DECISION DELEGATED TO HEAD OF PLANNING

Application No:	H21-1250-21	Applicant:	Ann Trett
Proposal:	Proposed demolition of existing office and erection of 1 no. 3 bed dwelling		
Location:	Land West Of 1 East Road Tydd Gote Wisbech		
Terminal Date:	21st May 2022

Proposed Ground Floor
1 : 100

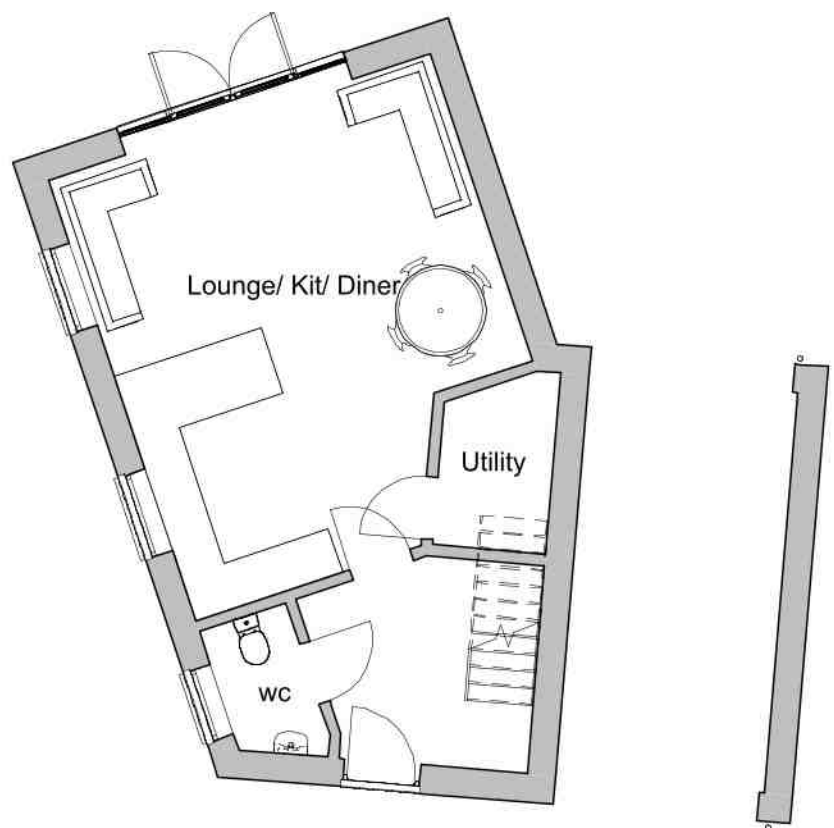
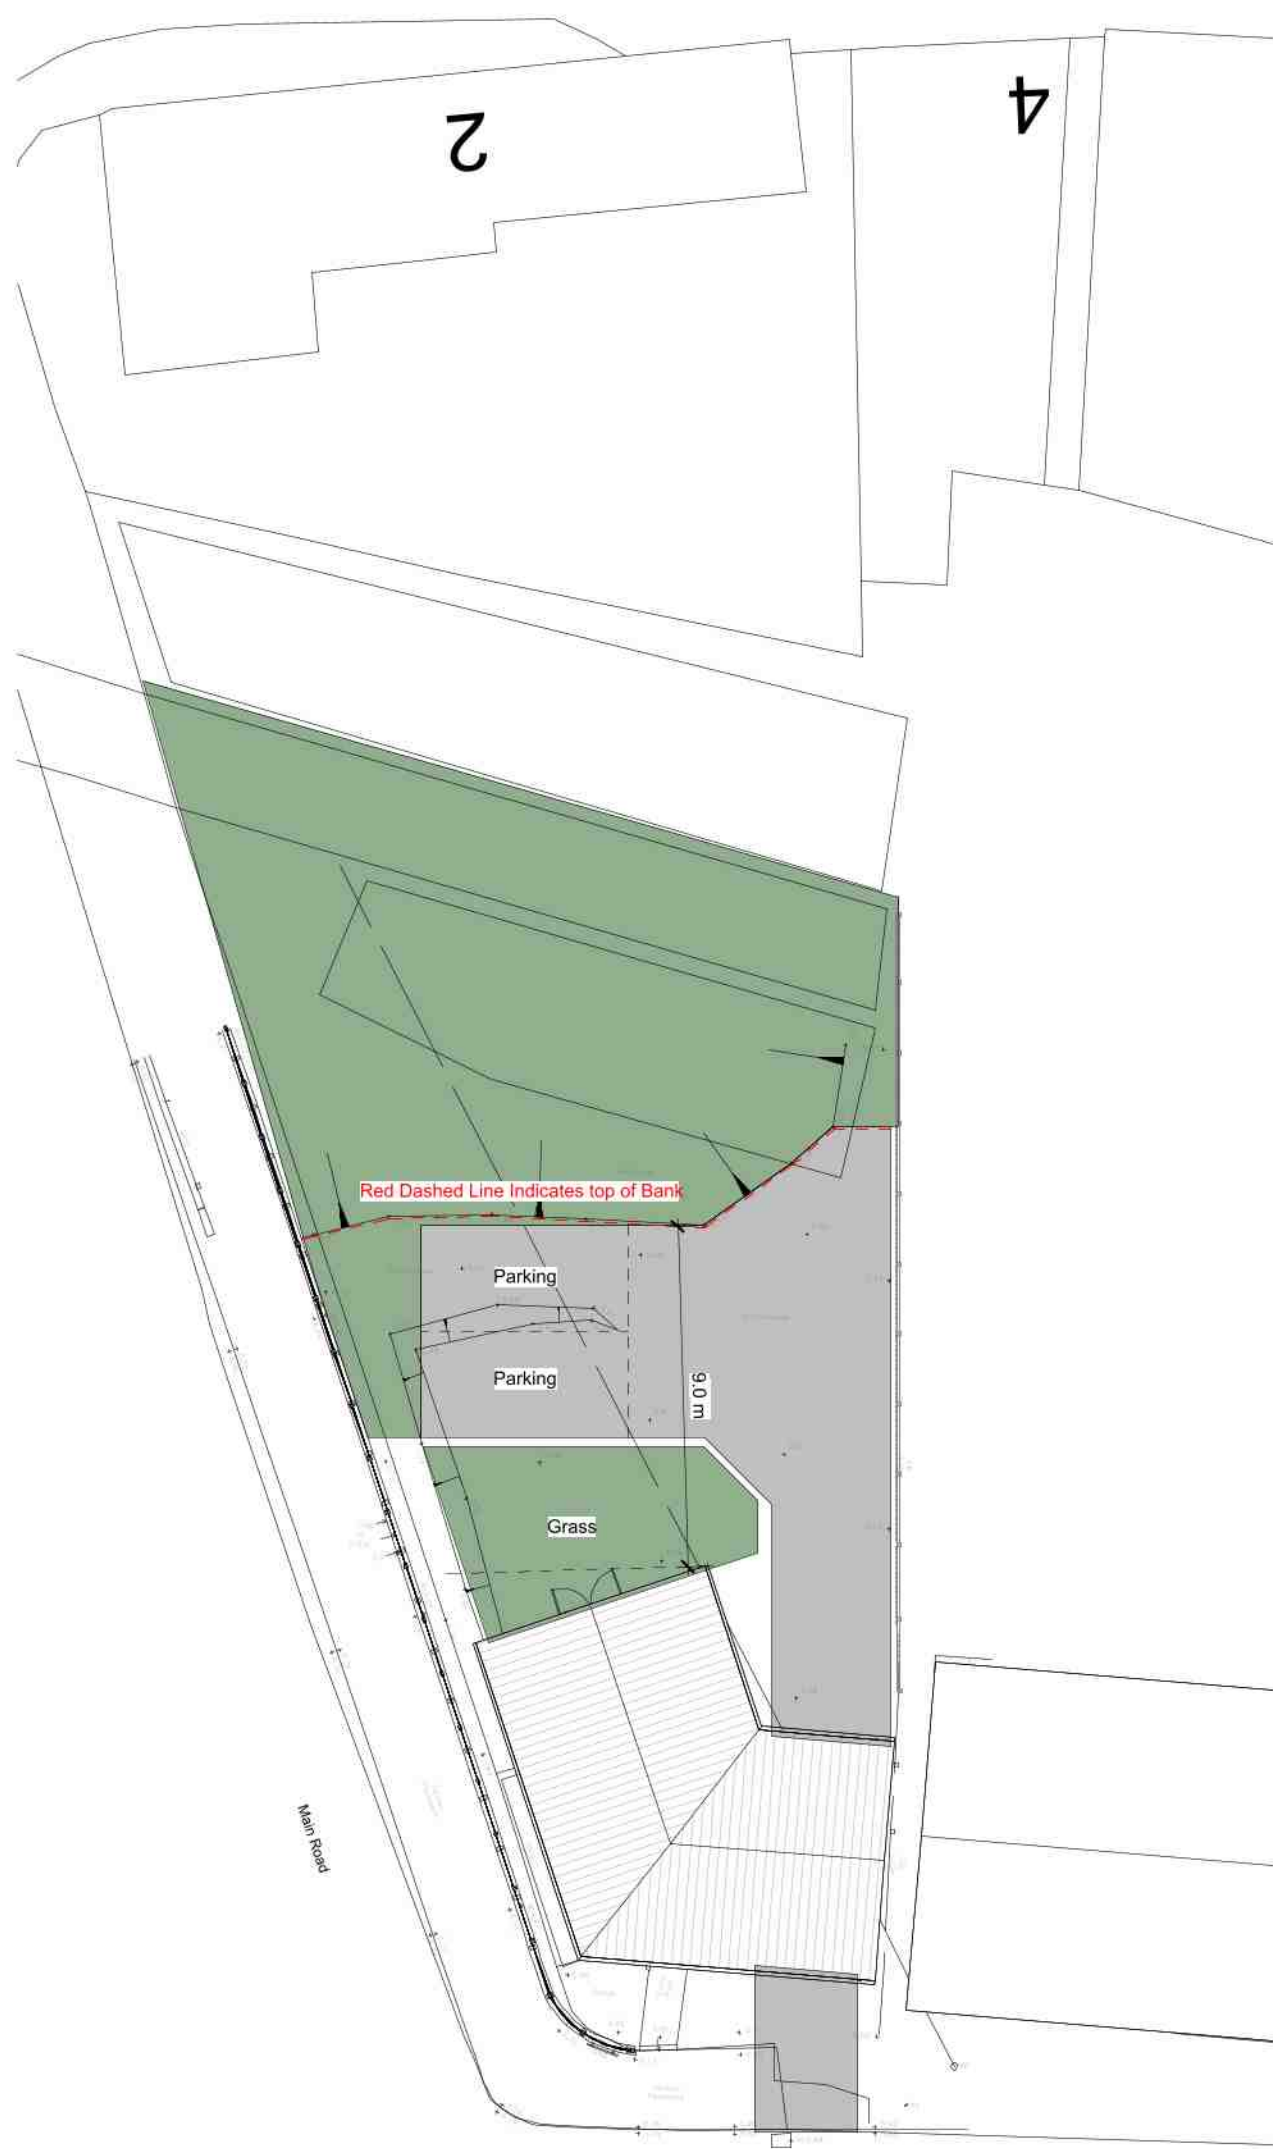
Plans need to show access to shower room.

Proposed Site Plan
1 : 200

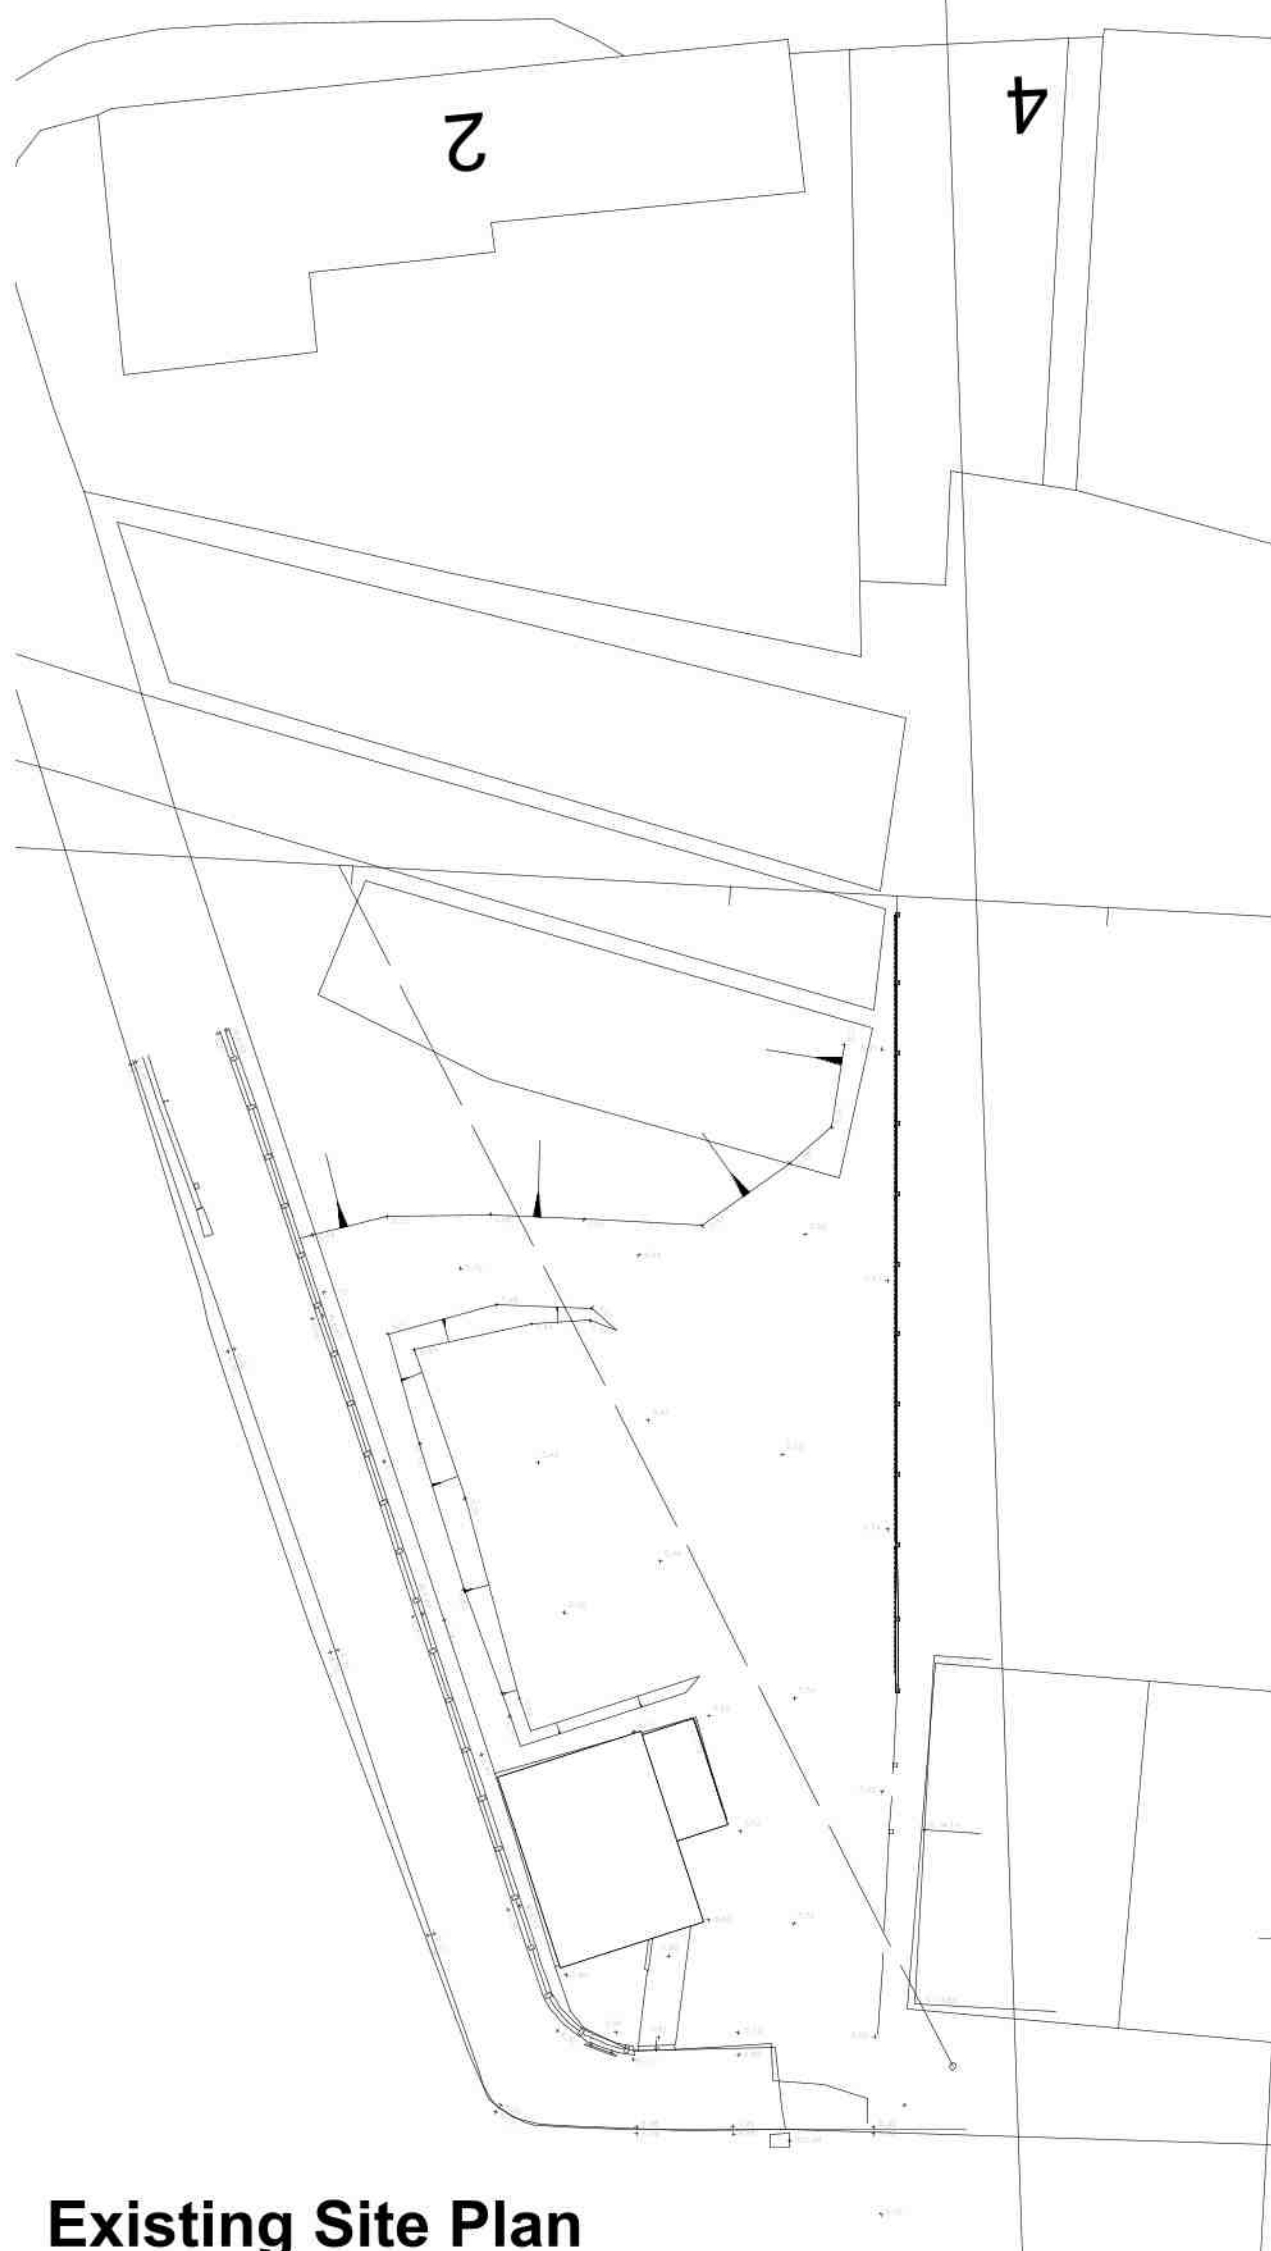
Object to any development that would breach Byelaw 10 which states that "no person without the previous consent of the Board shall erect any building or structure whether temporary or permanent within 9 metres of the drain"

It is understood that foul water would be disposed of to the mains sewer and surface water to the drain to the north of the site. The latter would remain open and would be more than 9 metres from the dwelling.
